Holbeach Road, Spalding

Highways Technical Note

Response to Highways Comments from Lincolnshire County Council

Planning Application Reference: 25/0704/FUL

Appendix E
Traffic Flow Diagrams

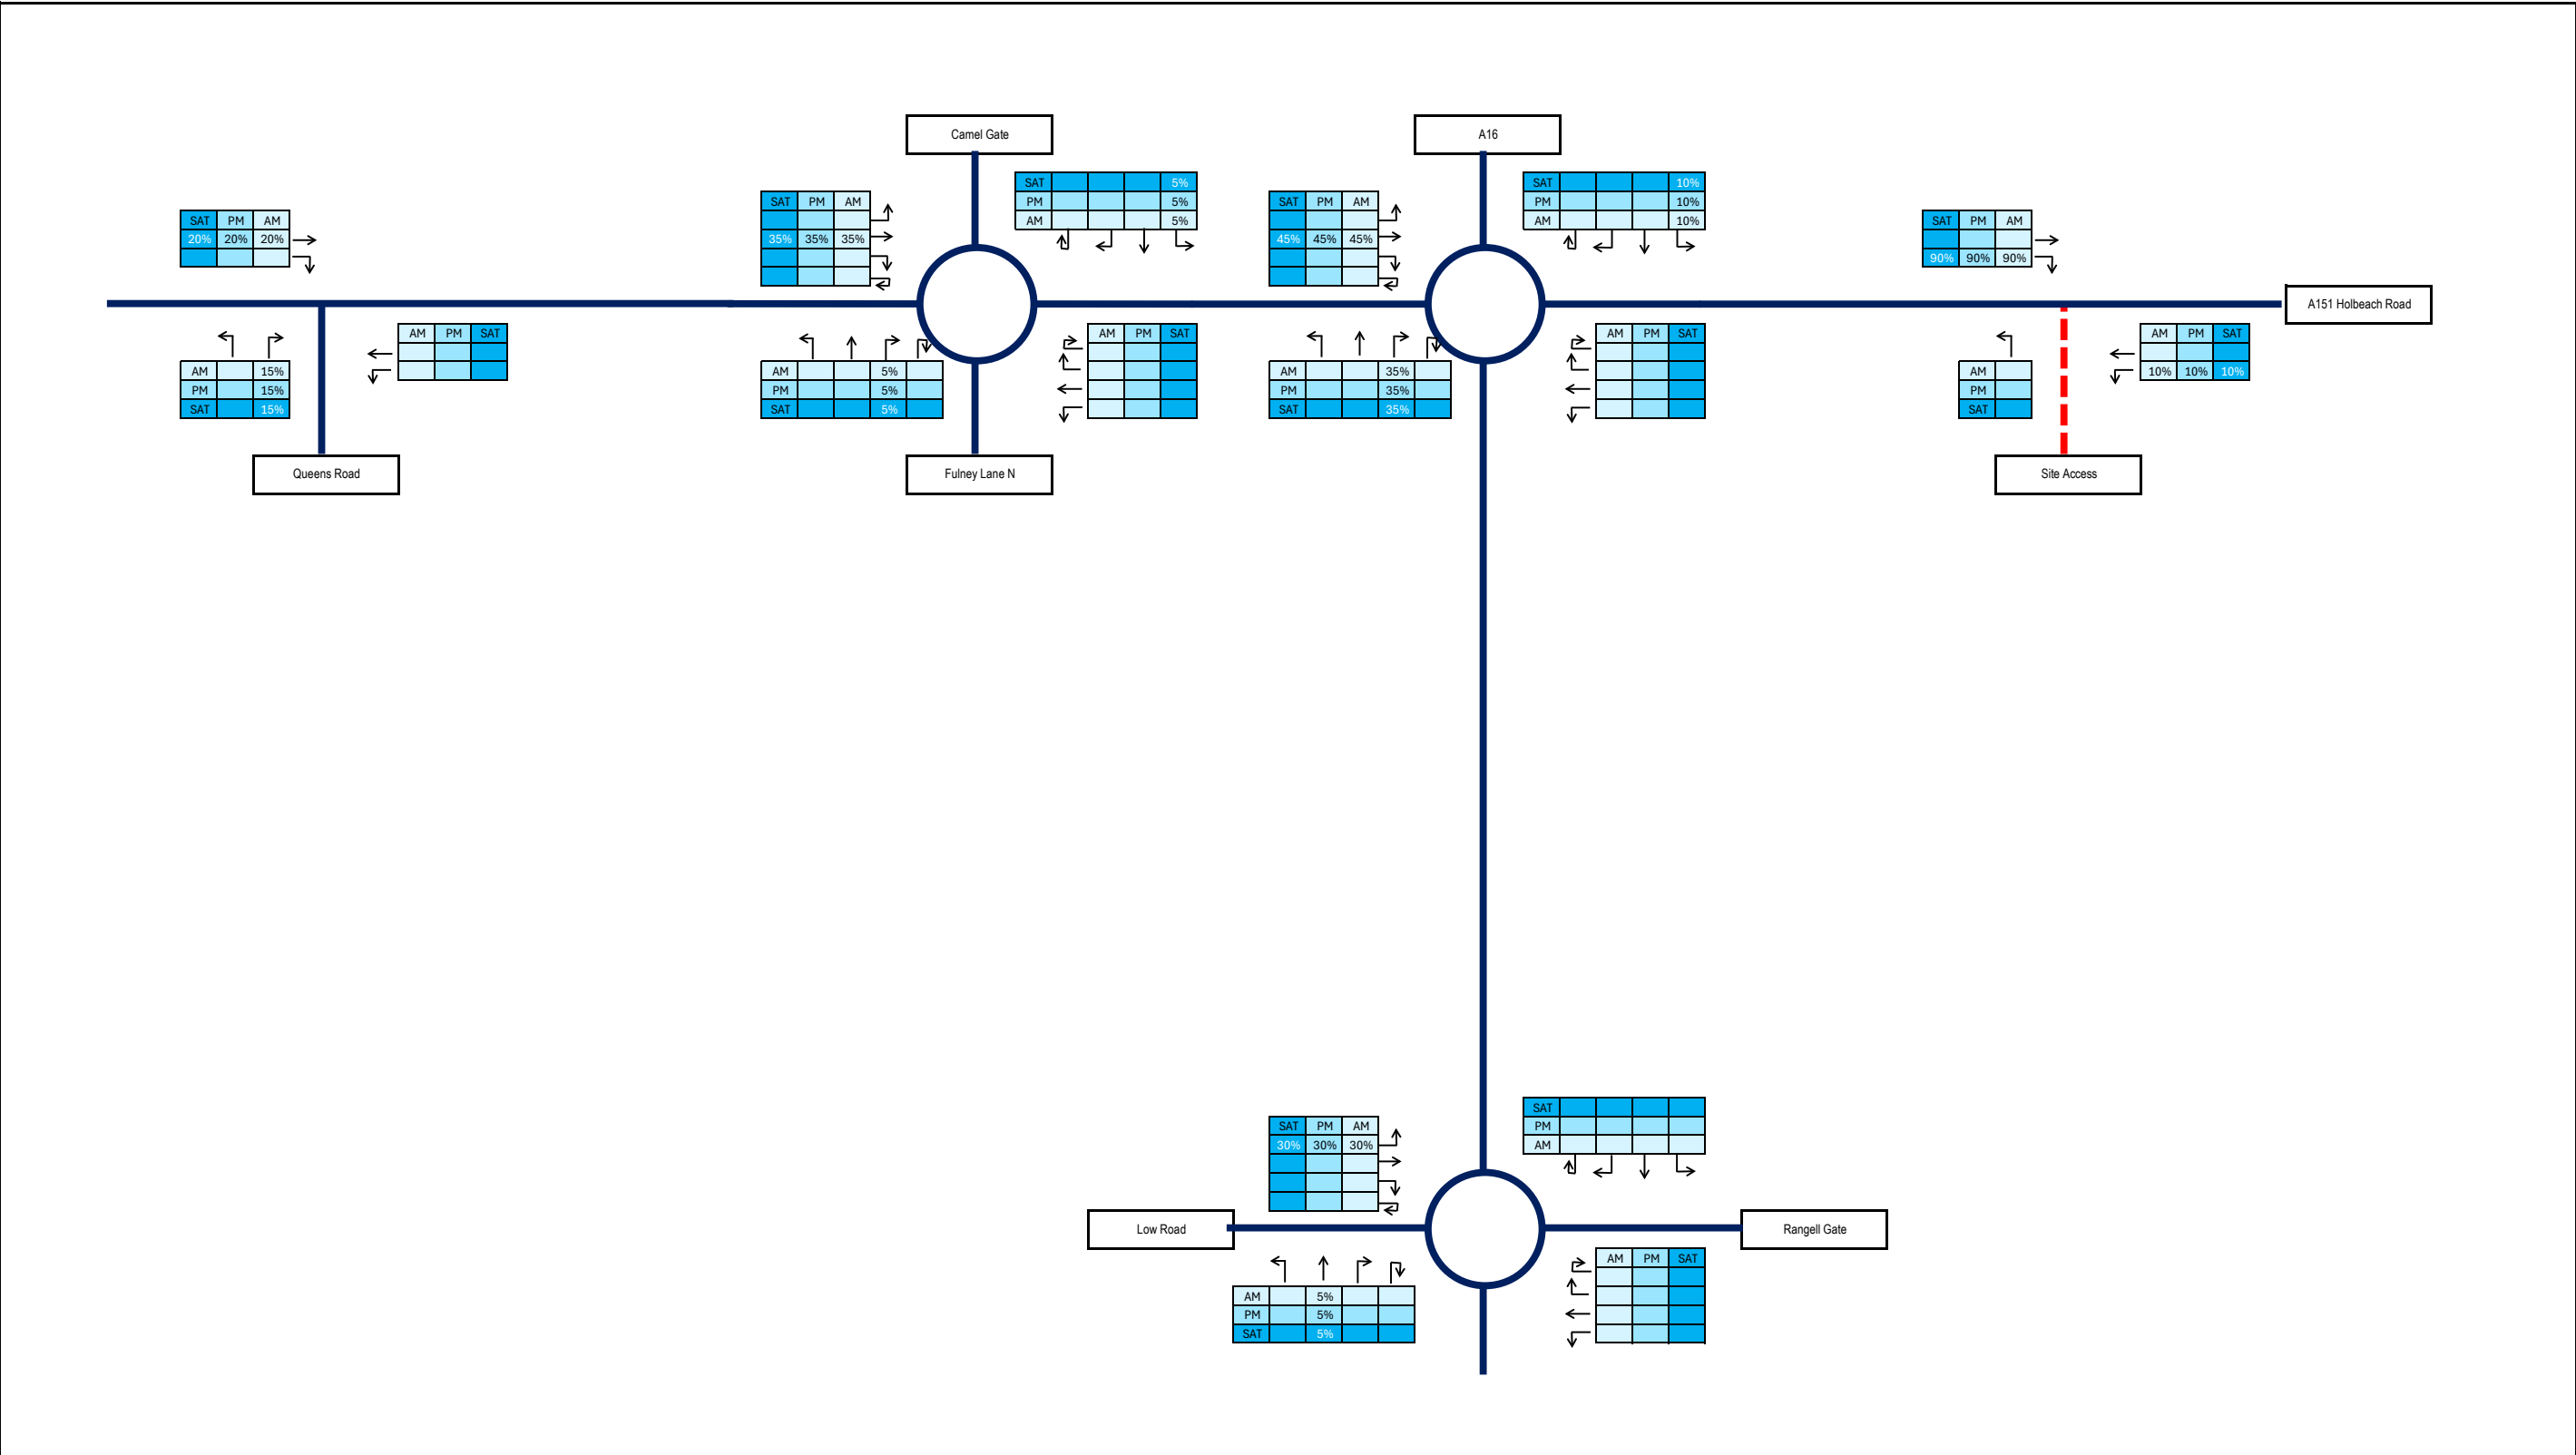
We have significant concerns about the access arrangements. Pre app discussions were based on different access arrangements.

The A16 roundabout improvement scheme designed Ghost Island Right Turn Lane for residential use and is as existing. It is not built to DMRB standard. Stacking is not available for service vehicles expected to visit the site. There is the potential for vehicles to back up over the roundabout - capacity concerns.

There is significant highway signage that will need moving to accommodate the access – this has not been addressed and relocation details provided. The street lighting may also need moving.

The tracking is unworkable at peak hours as HGV's will need to take up both lanes exiting the site. The swing that is needed can't be achieved on the access road without moving the stone pillars – we need security that they can be moved.

While it is noted that the access junction doesn't comply with DMRB in terms of the length of the ghost island right-turn facility, it is still considered acceptable in this location. This is due to the proximity of the site access junction to Springfield Roundabout. A 50m ghost island right-turn facility is typically required on a 40mph road which is required for deceleration. Drivers entering the right-turn ghost island facility in this location will be exiting Springfield Roundabout, therefore, a 50m length is not required. A 38m ghost island facility in this location is considered appropriate given that it's similar to the 35m requirement for a 30mph speed limit. Vehicles exiting Springfield Roundabout onto the A151 Holbeach Road are likely to be travelling at 30mph before accelerating towards the 40mph speed limit as they continue north-eastbound on the A151 Holbeach Road.

In terms of stacking spaces for a HGV waiting to turn right into the site, 38m is more than sufficient given that a max legal articulated HGV is 16.5m long.

Items such as relocating signage and street lighting can be dealt with at the detailed design stage.

The site will have a delivery strategy in place that ensures that HGVs arrive outside of the peak periods. The stone pillars will be removed / relocated as they conflict with the eastern carriageway edge of the proposed site access road.

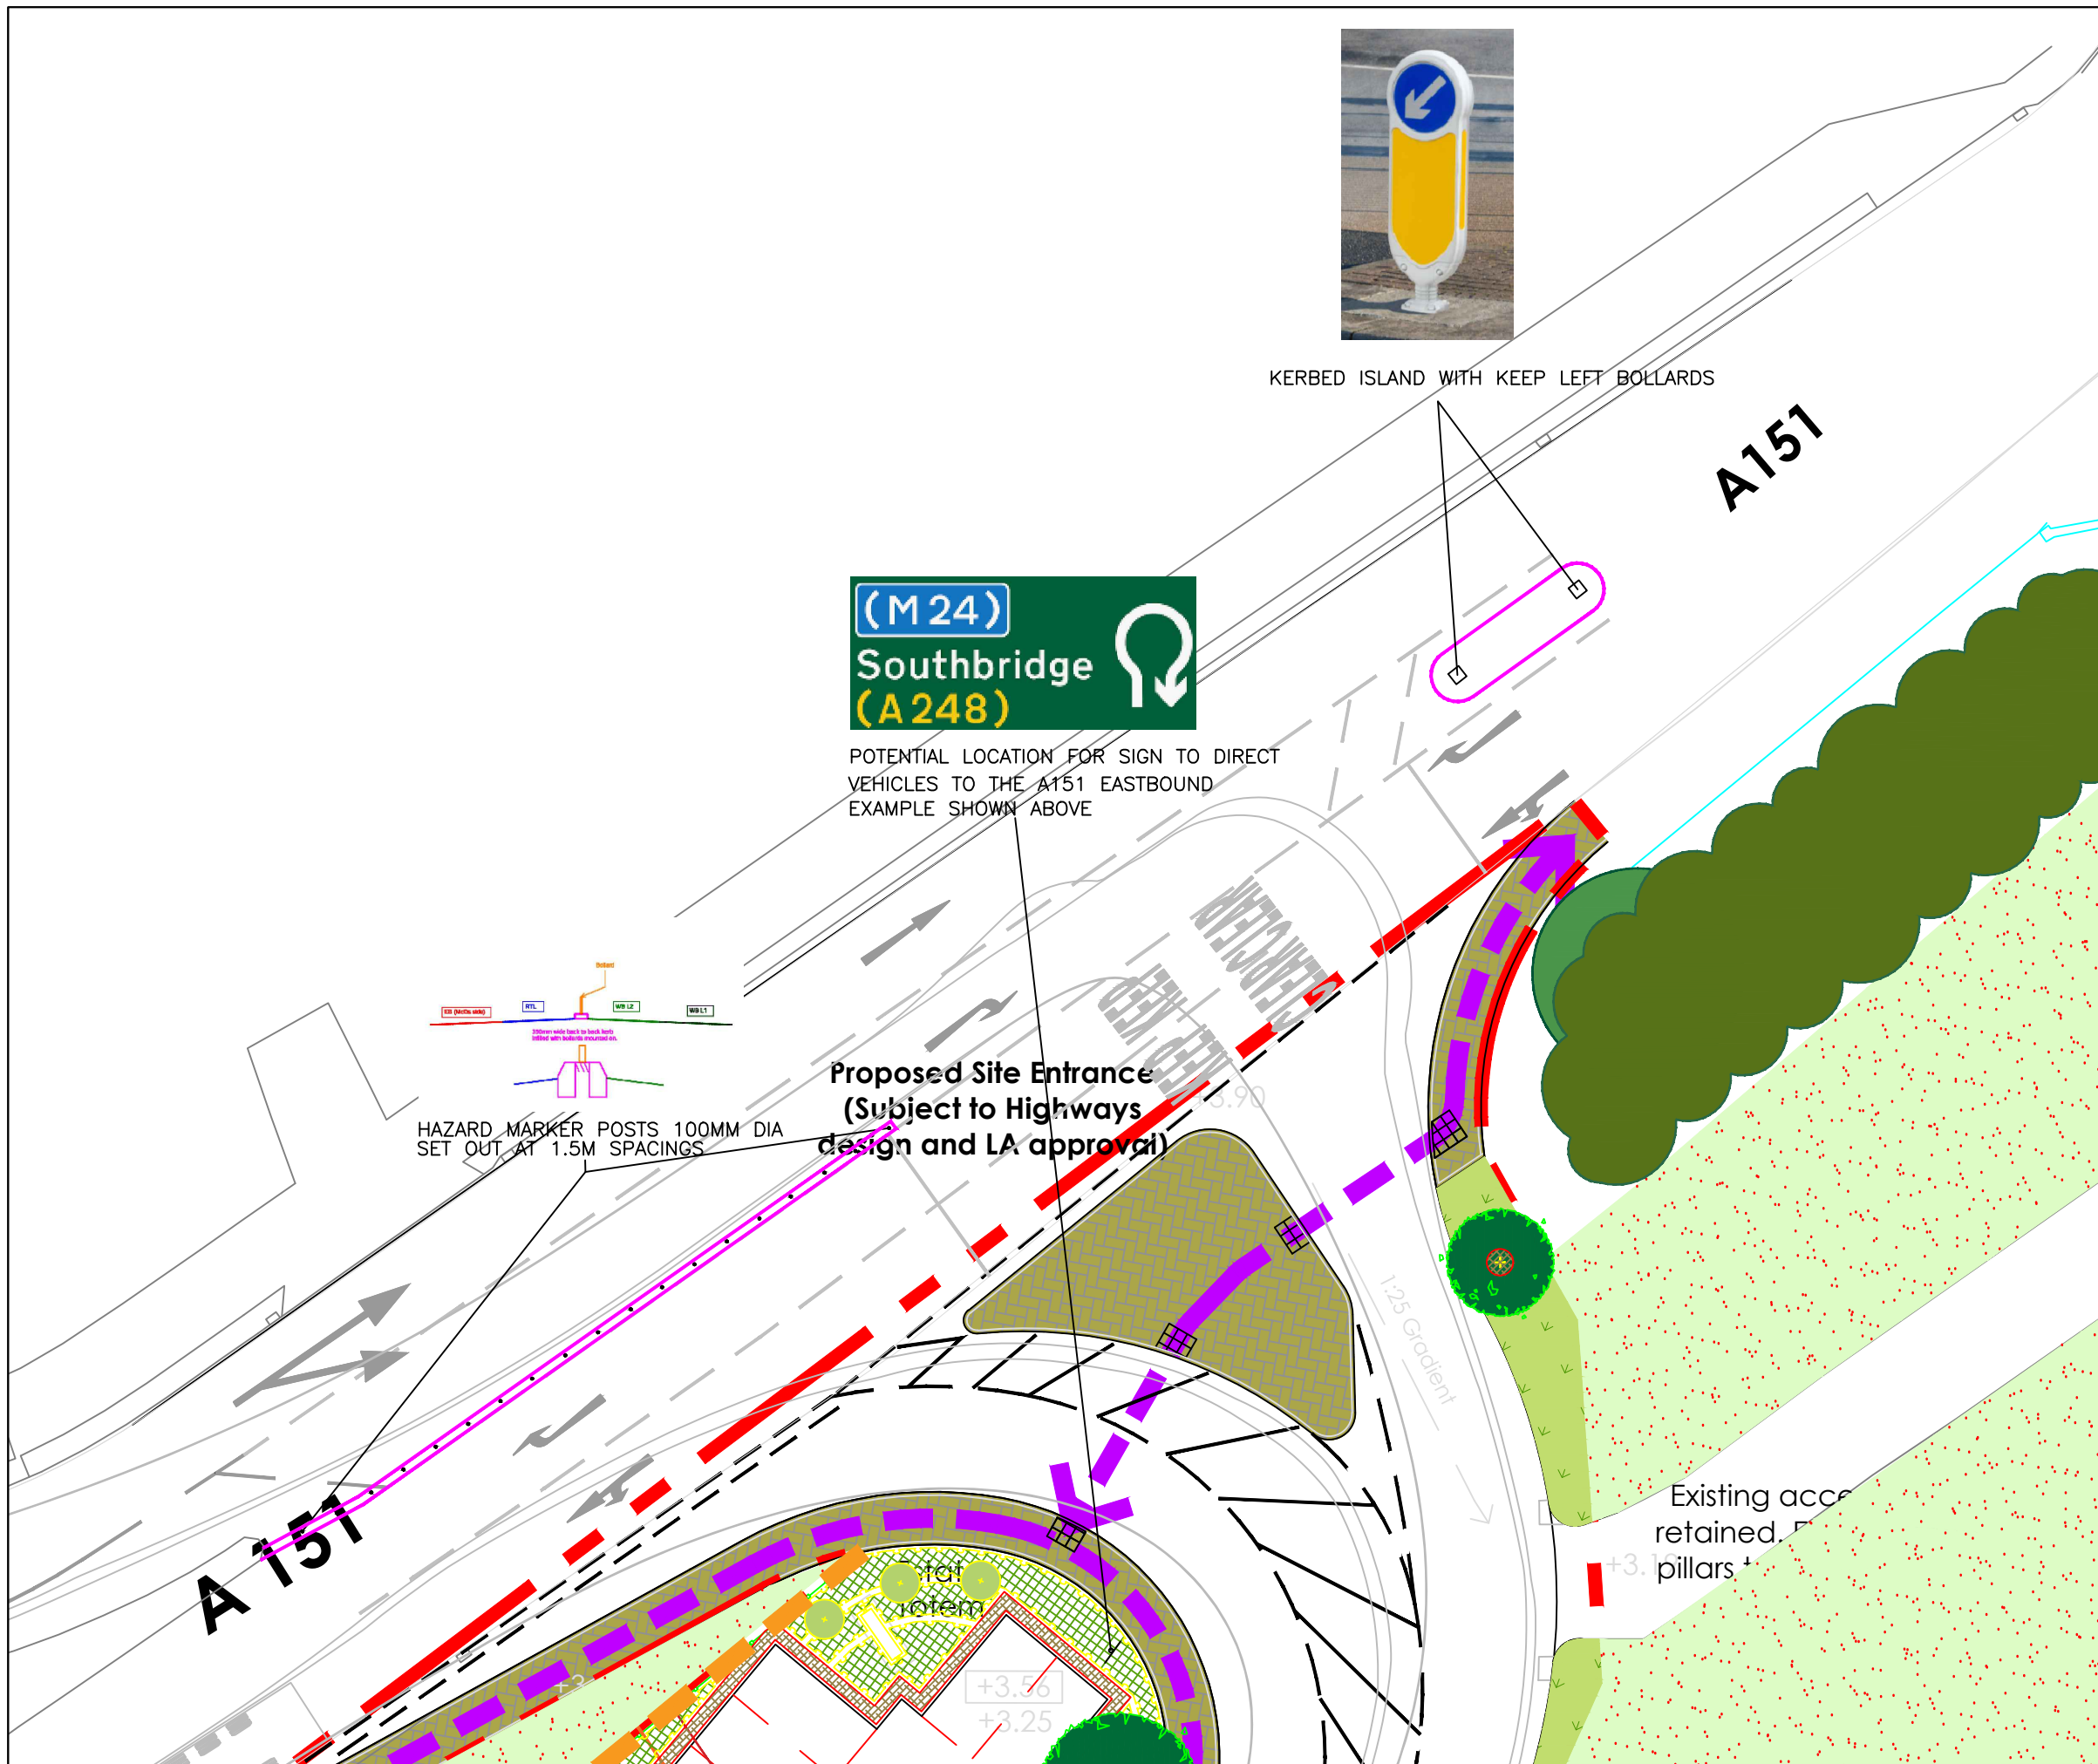
The Transport Assessment does not address safety and the accident data detailed is out of date. Concerns internally with queuing – particularly with it being a Drive Thru and how they operate. There should be a right turn lane internally to the Coffee Drive Thru so that queues internally do not back up into the highway.

The distance from the site access on Holbeach Road and the entry to the drive thru lane is approximately 93m. This distance could accommodate 16 vehicles without blocking back onto the adopted highway which is considered more than sufficient for any spikes in demand.
